Your Ref: OWPC22188
Our Ref: FP/46/19/PL 20-02-2019
Please ask for:
Amber Willard

Application for variation of condition no 2 imposed on planning reference FP/205/18/HH
relating to amended design
28 Sea Drive Felpham

Dwg Reference:
Roof plan as proposed

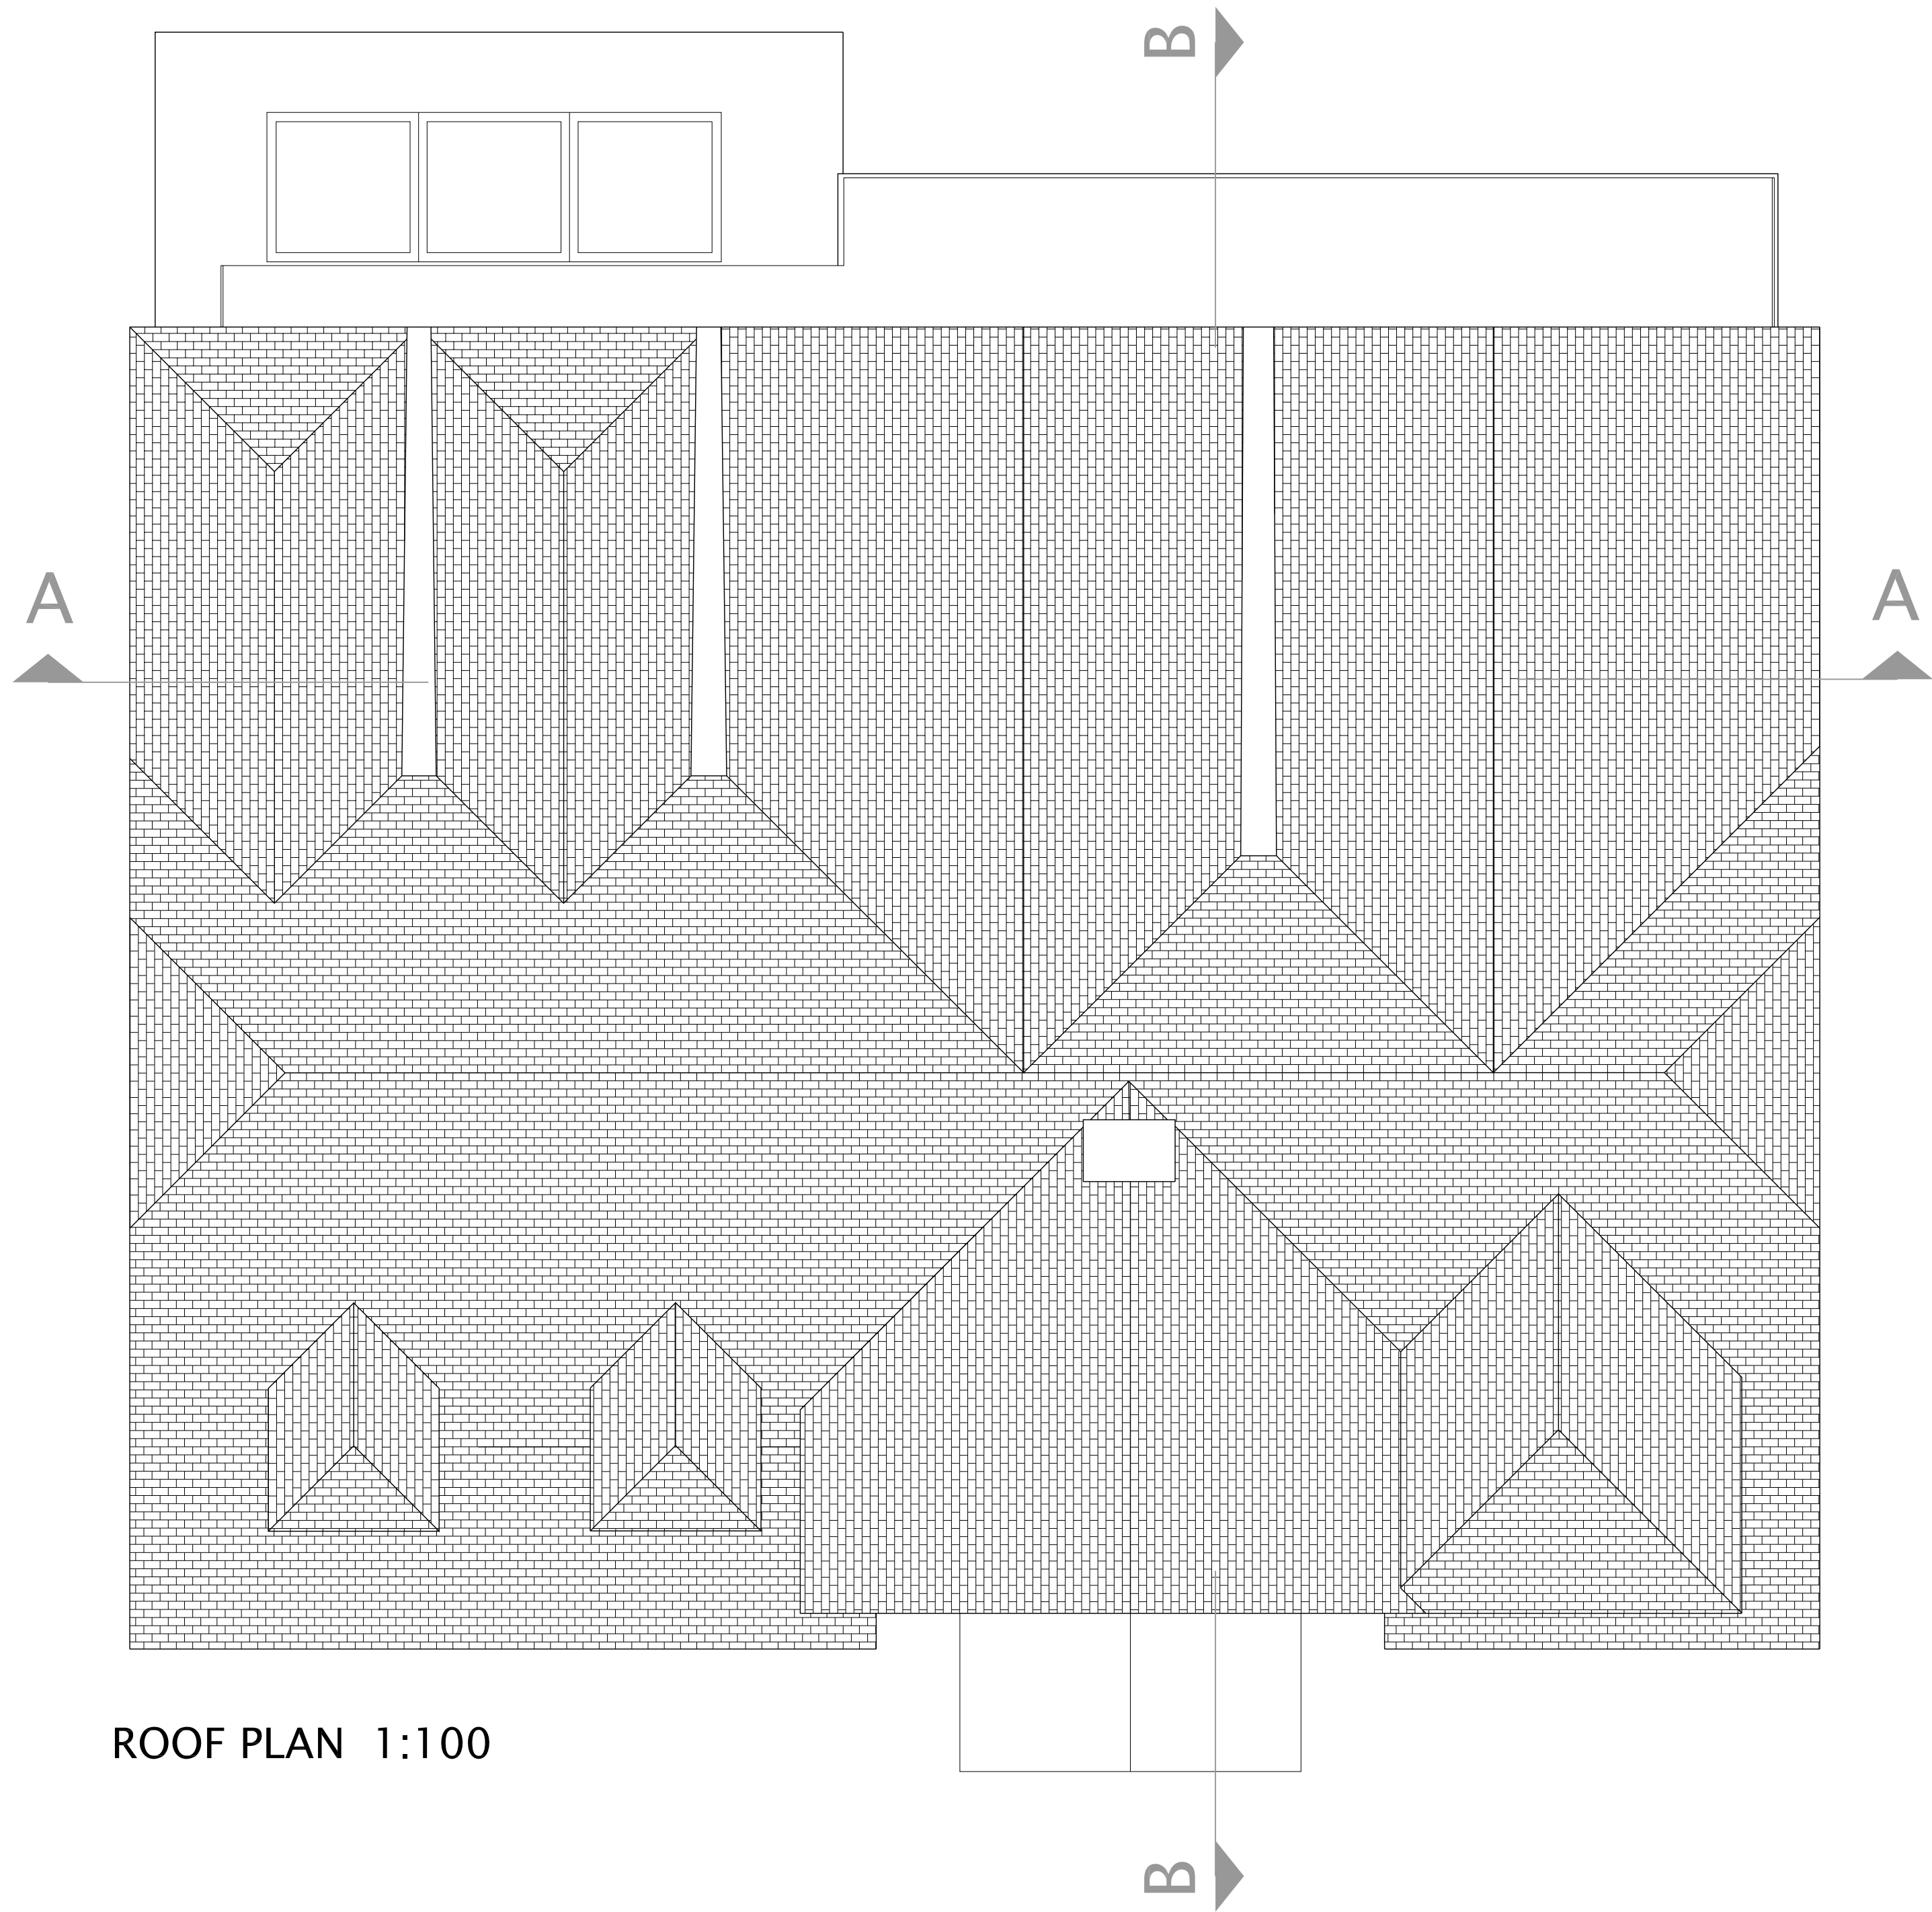
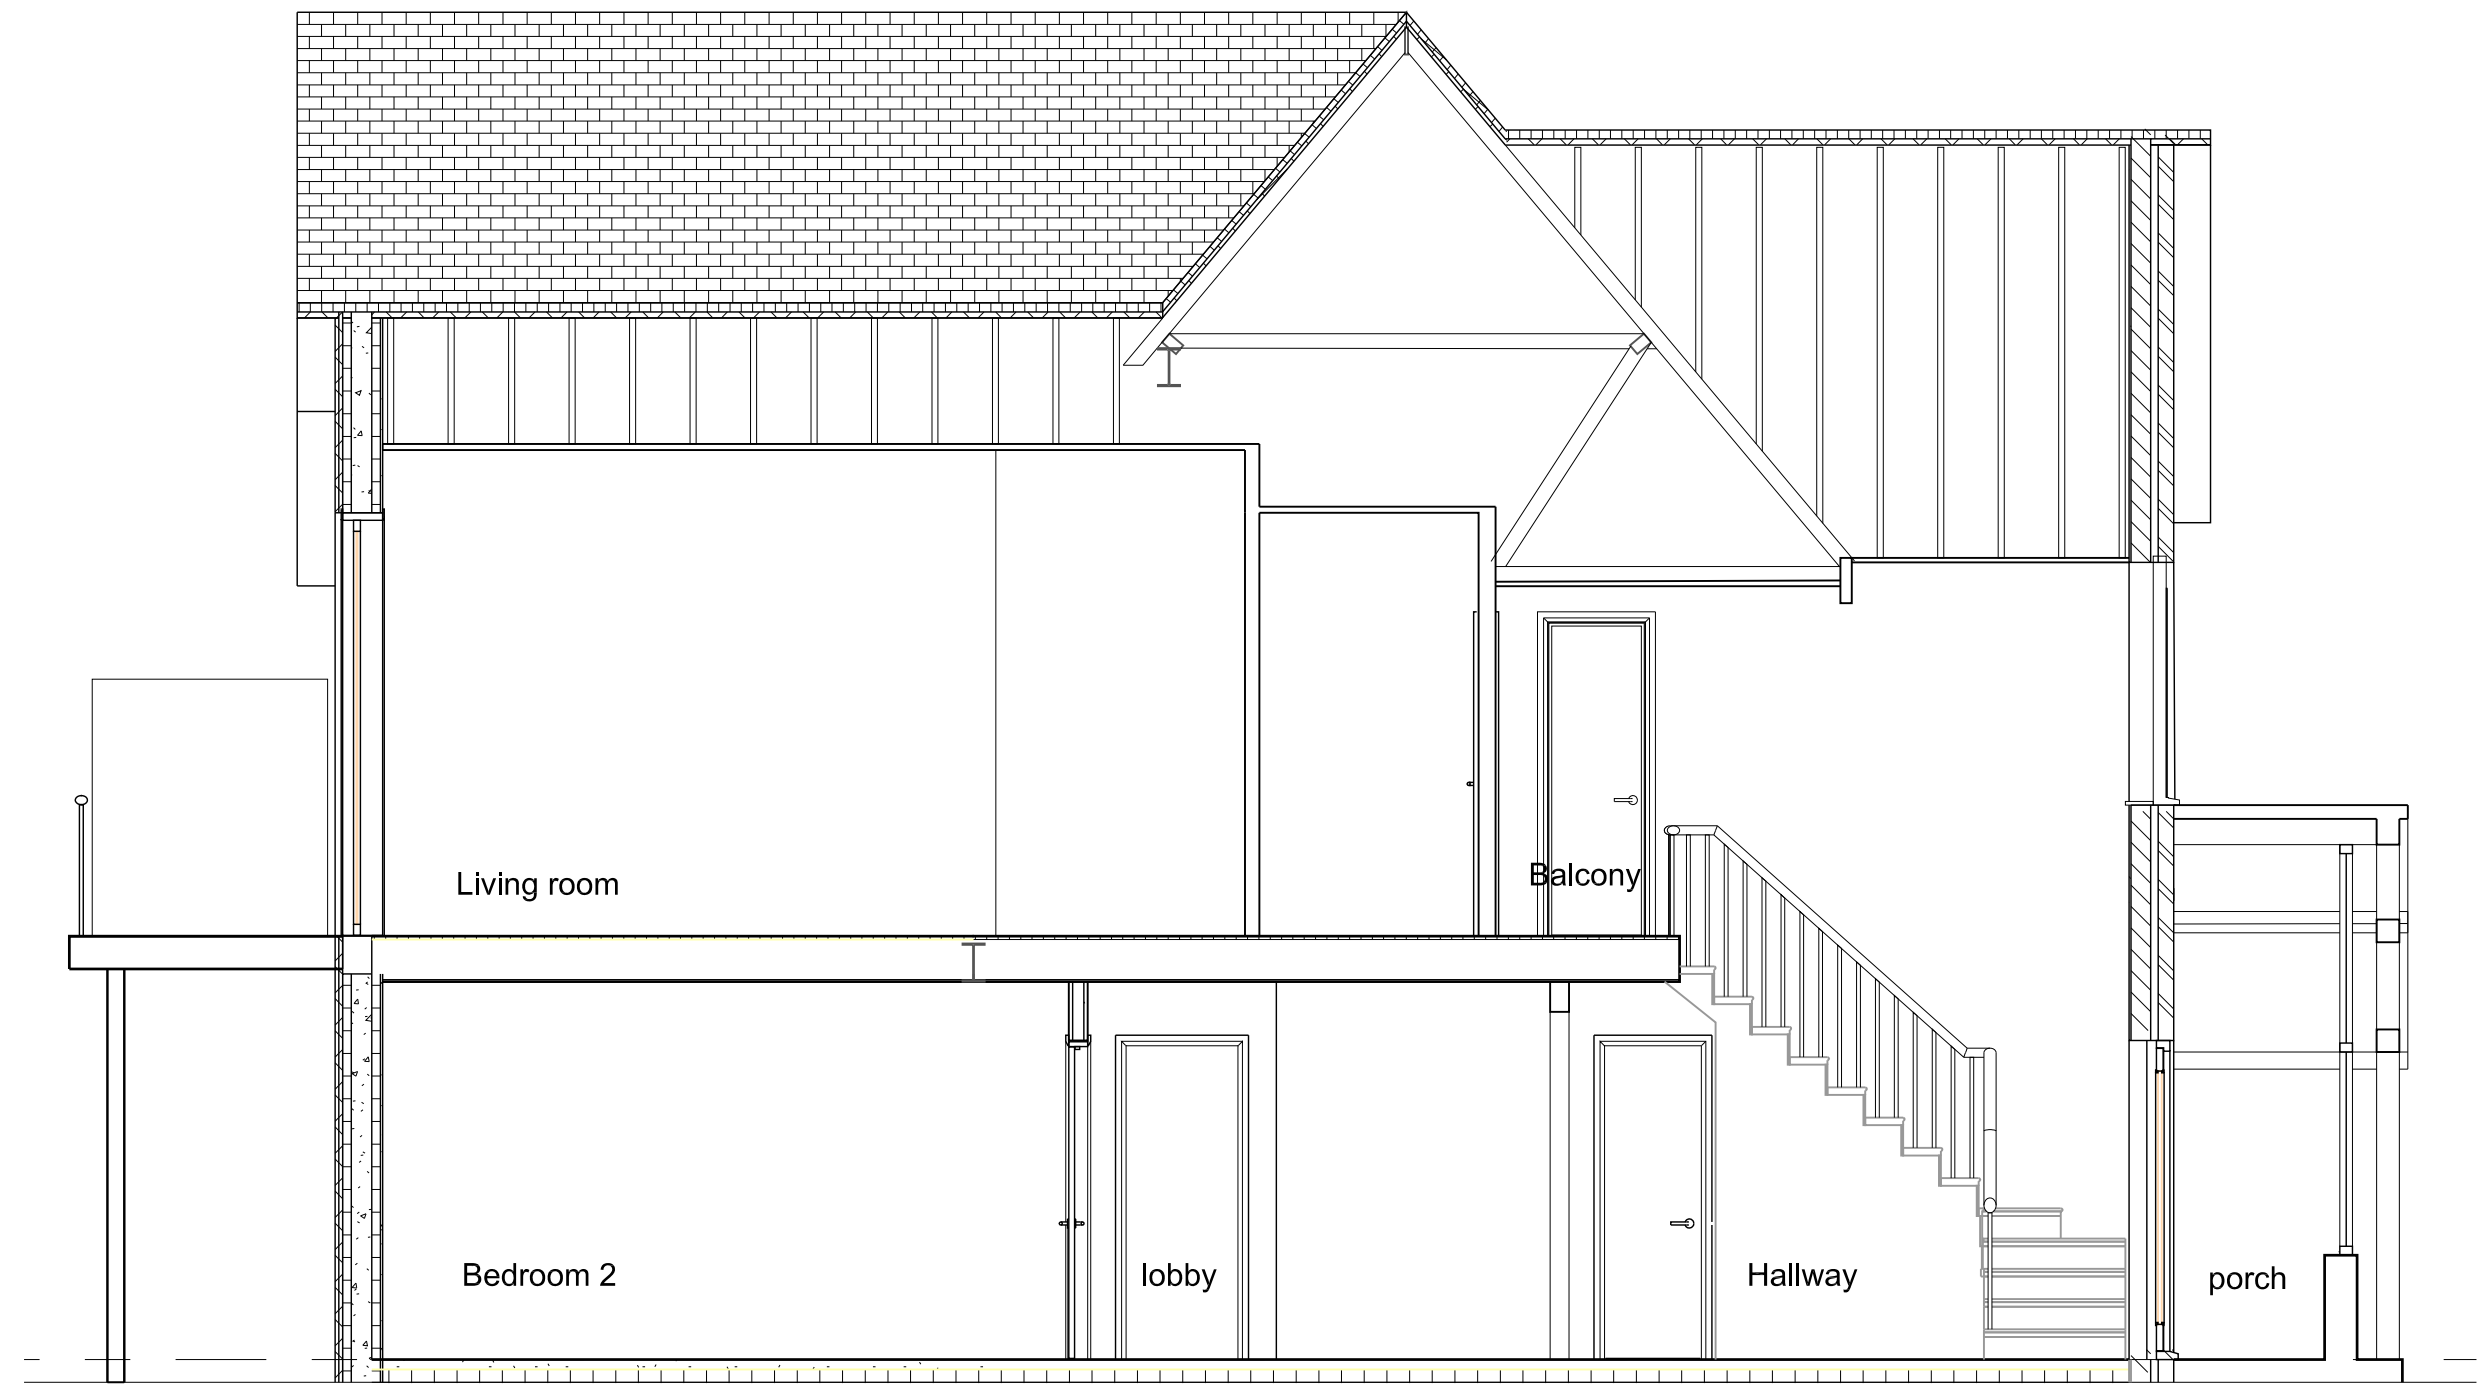
*This amendment, is further over development of the site.
The proposed extension over the garage, with no step back, therefore taking the development to the very edge of the property, is overbearing, and monolithic.
The effect Upon number 27 coming to within less than a metre of their boundary, will be to crowd it and potentially rob it of light, and privacy.
At the rear property sea facing, the present building line of adjacent properties at 29,27, and 26 Sea Drive, is simply ignored, as the property creeps ever forward across the garden.
The fact that the owner of the house and application, owns the land, does not give an automatic right to build across it, at the detriment to the neighbours, and others in close proximity.
This amendment seeks to expand the existing consent by stealth, increasing the net saleable square footage substantially, and simply not in keeping with the current plot size.
